Road Safety Audit Report

Incorporating
Stage 1 Completion of Preliminary design

The Old Dairy Littlehampton

Graham Nicolls Ltd

CLIENT	Graham Nicolls Limited		
PROJECT	The Old Dairy, Little Hampton		
TITLE	Fire Tender accessing the site, turning and egressing		
DRAWN BY	GPW	CHECKED BY	GPW
DATE	16/12/13	DATE	4429/201
SCALE	1:250 @ A3	SCALE	4429/201
		SCALE	B

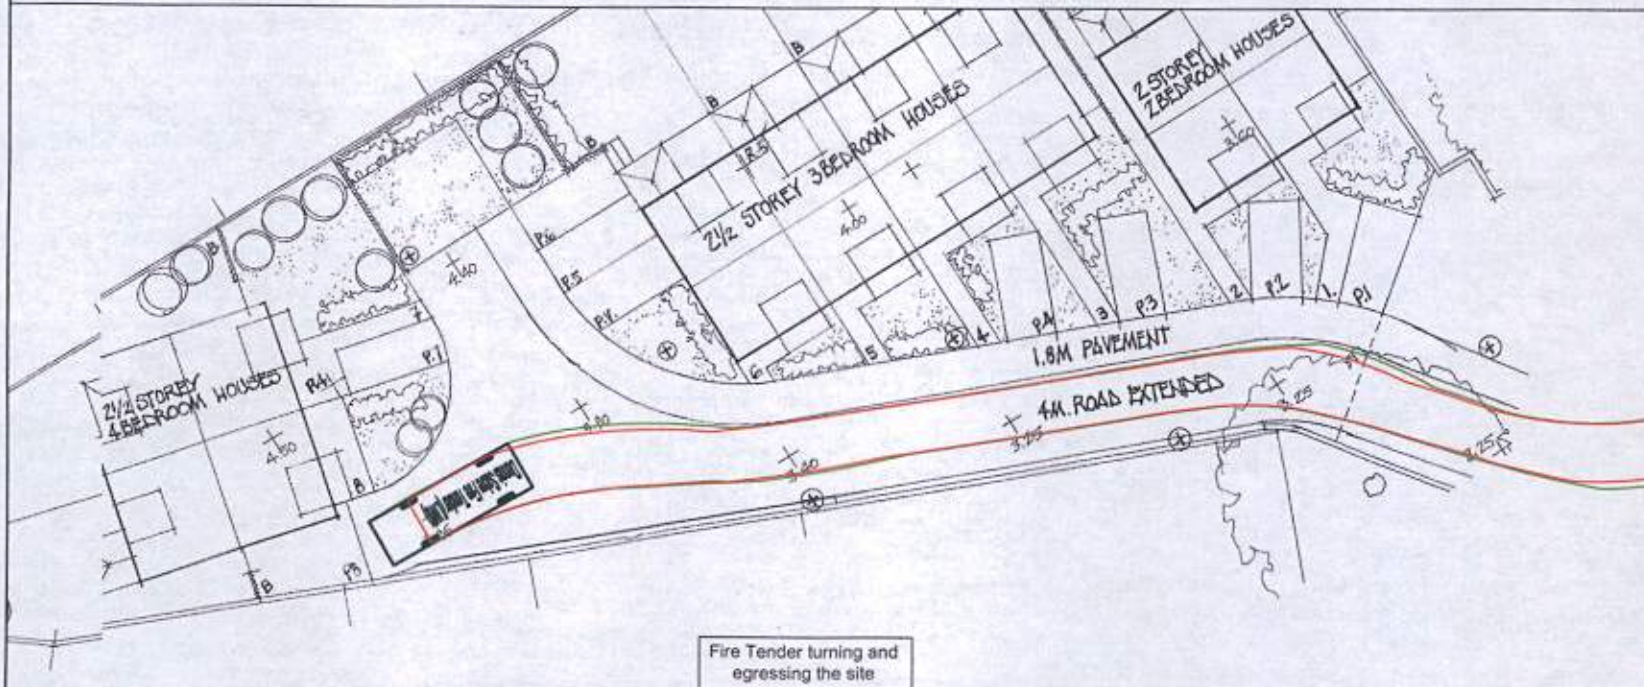
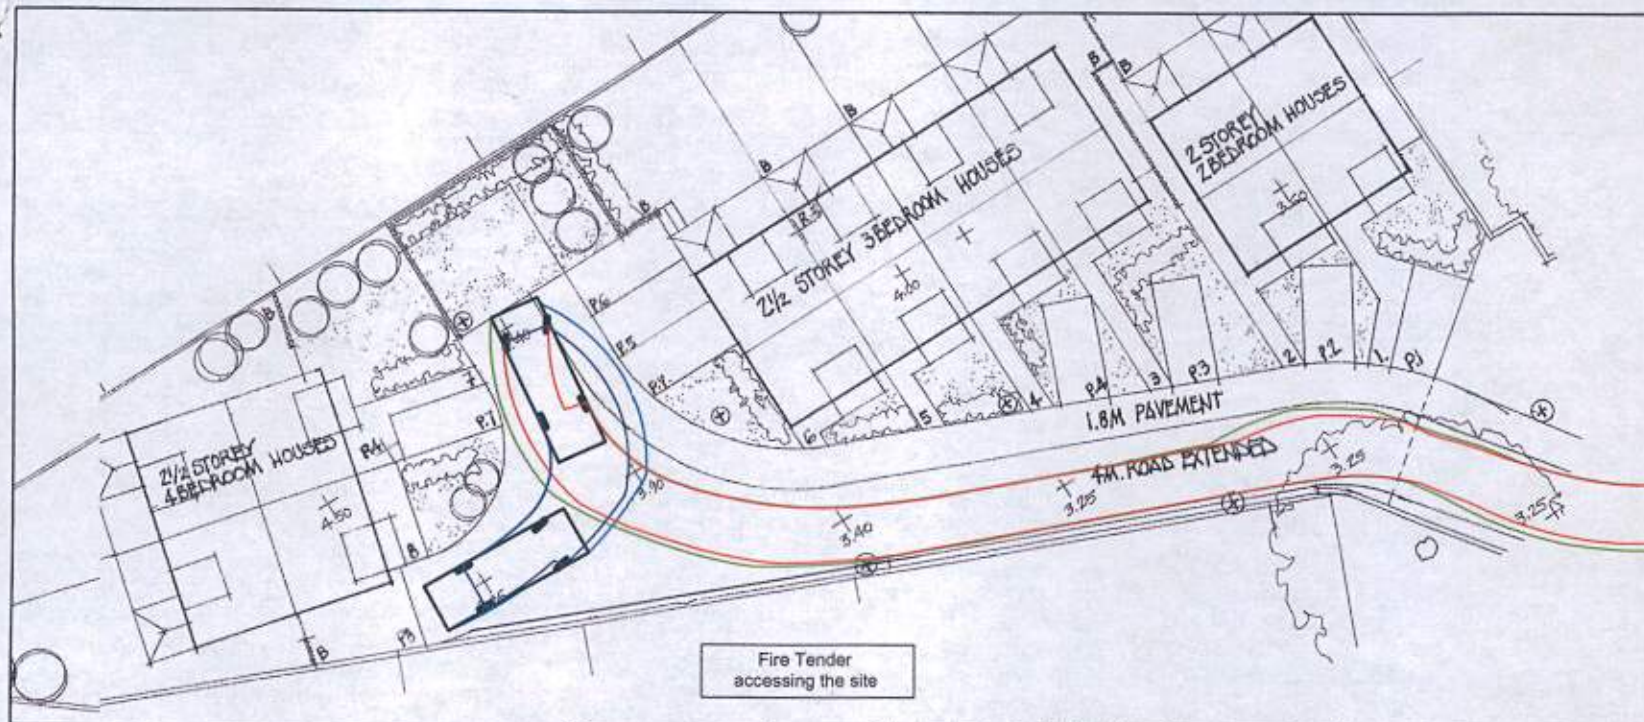
Item No.	Audit Team Observation	Audit Team Recommendation	Designer / Scheme Response
1	GENERAL		
1.1	Comment <i>On-street Parking extends over the access</i> Accident Type <i>Side Collisions</i> Location <i>Adjacent to the access</i> The existing on-street parking bay along Church Street, extends over the access and whilst it is not likely that a vehicle will park blocking the entire access, a vehicle could park in such a location that the width of the access is restricted. Reducing the access width could result in vehicles becoming misaligned to egress/access the site and raises the likelihood of vehicle collisions. Furthermore, a vehicle parked over the access is likely to restrict visibility to pedestrians.	The existing parking bay should be modified to terminate at appropriate locations either side of the access and the use of double yellow lines should be considered.	Discussions will be held with the Local Highway Authority to amend the parking bay appropriately.
